Our Ref: 15756  
Council Ref: SSDA 7317 MOD 13

## **SSDA 7317 – MOD 13 - SECTION 4.55(1A) MODIFICATION APPLICATION BUILDING 1, AUSTRALIAN TECHNOLOGY PARK, EVELEIGH**

The purpose of this modification request is to seek approval for an extension of the external terrace area at the Lower Ground Level of Building 1.

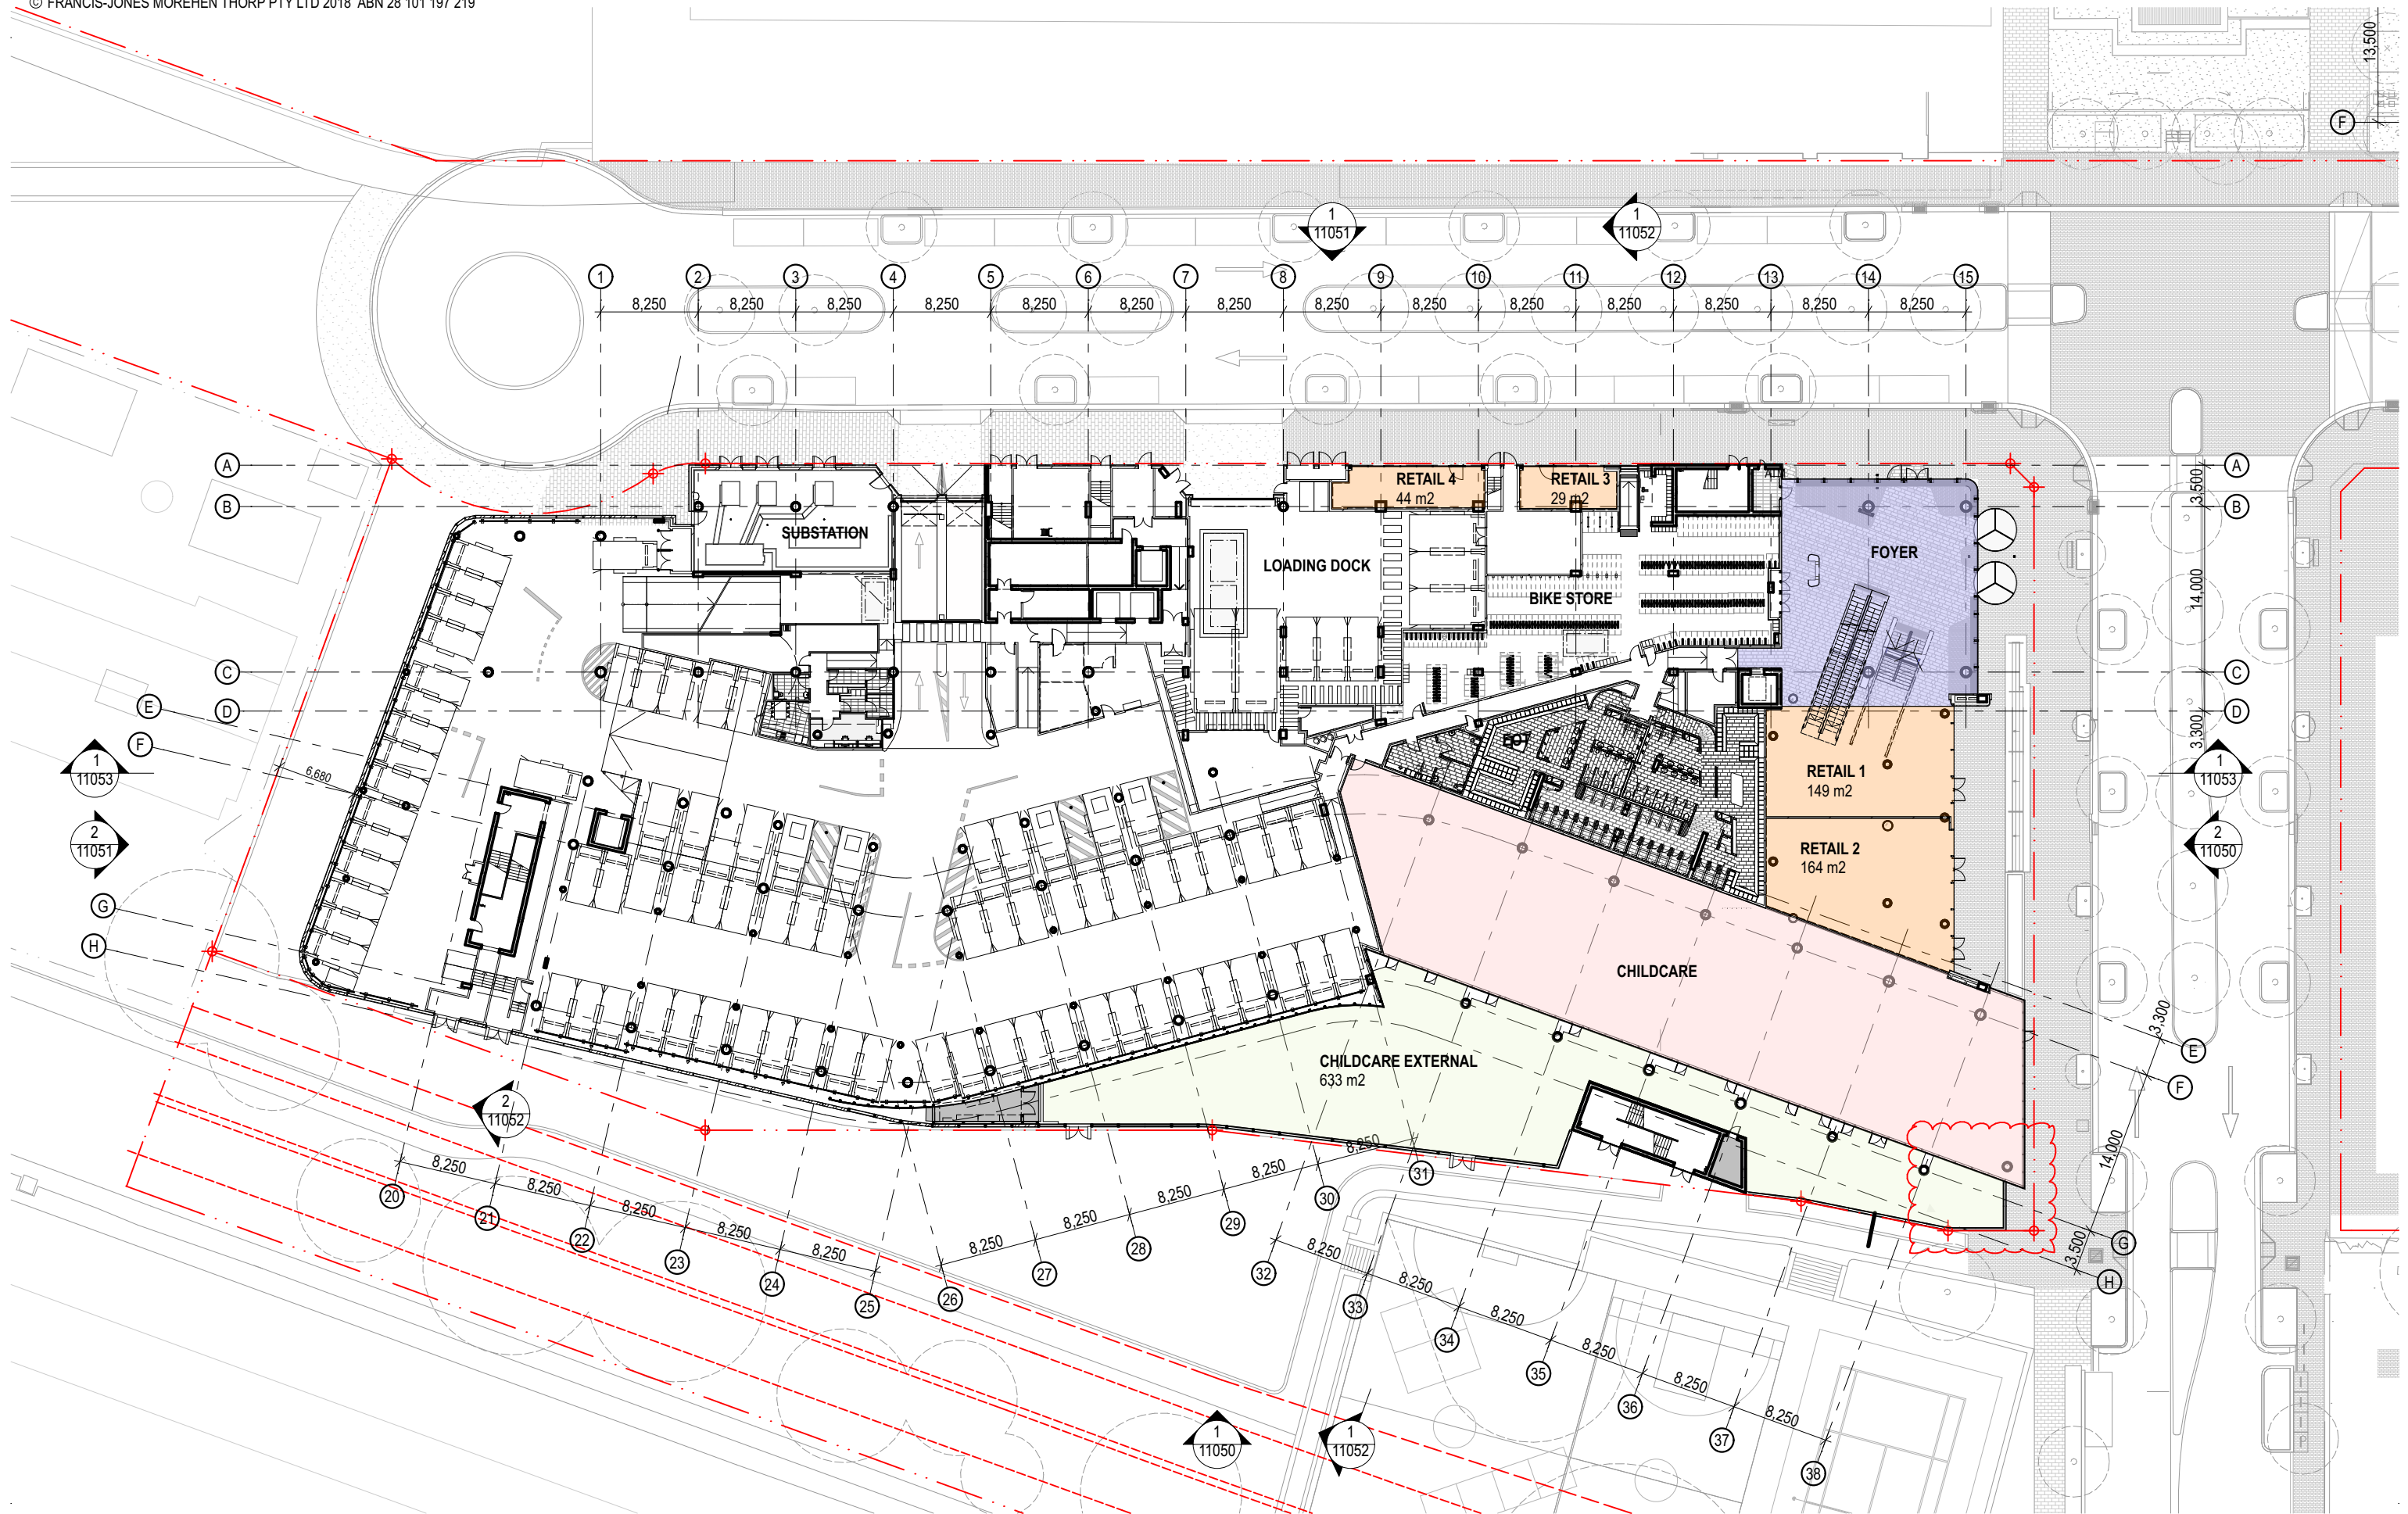
The central zone of the child care external area slab and footings at the Lower Ground Level of Building 1 have been built 300mm off the southern site boundary, instead of on the site boundary. This results in an undersupply of unencumbered outdoor space area for the childcare centre as 7m<sup>2</sup> per child required under the Education and Care Services National Regulations 2011.

In total 630m<sup>2</sup> of unencumbered outdoor space is required for the 90 space child care facility, therefore as indicated on the revised Architectural Plans (**Attachment A**), the proposed modification to the development consent involves the extension of the eastern external area associated with the child care centre. Specifically, the proposed amendment results in an extension of the outdoor terrace by 4.3m to a position where the child care fence is setback 2.5m from the eastern site boundary line. It is noted that the approved plans show a setback of 6.65m.

Drawing No.	Rev	Name of Plan	Date
<del>Fjmt-AR-DWG-1100L</del>	<del>DA5</del>	<del>Lower Ground GA Plan</del>	<del>03.04.18</del>
<i>fjmt-AR-DWG-1100L</i>	<i>DA6</i>	<i>Lower Ground GA Plan</i>	<i>26.06.18</i>
<del>Fjmt-AR-11050</del>	<del>DA9</del>	<del>Elevations – South &amp; East</del>	<del>06.02.18</del>
<i>fjmt-AR-DWG 11050</i>	<i>DA11</i>	<i>Elevations – South &amp; East</i>	<i>26.06.18</i>
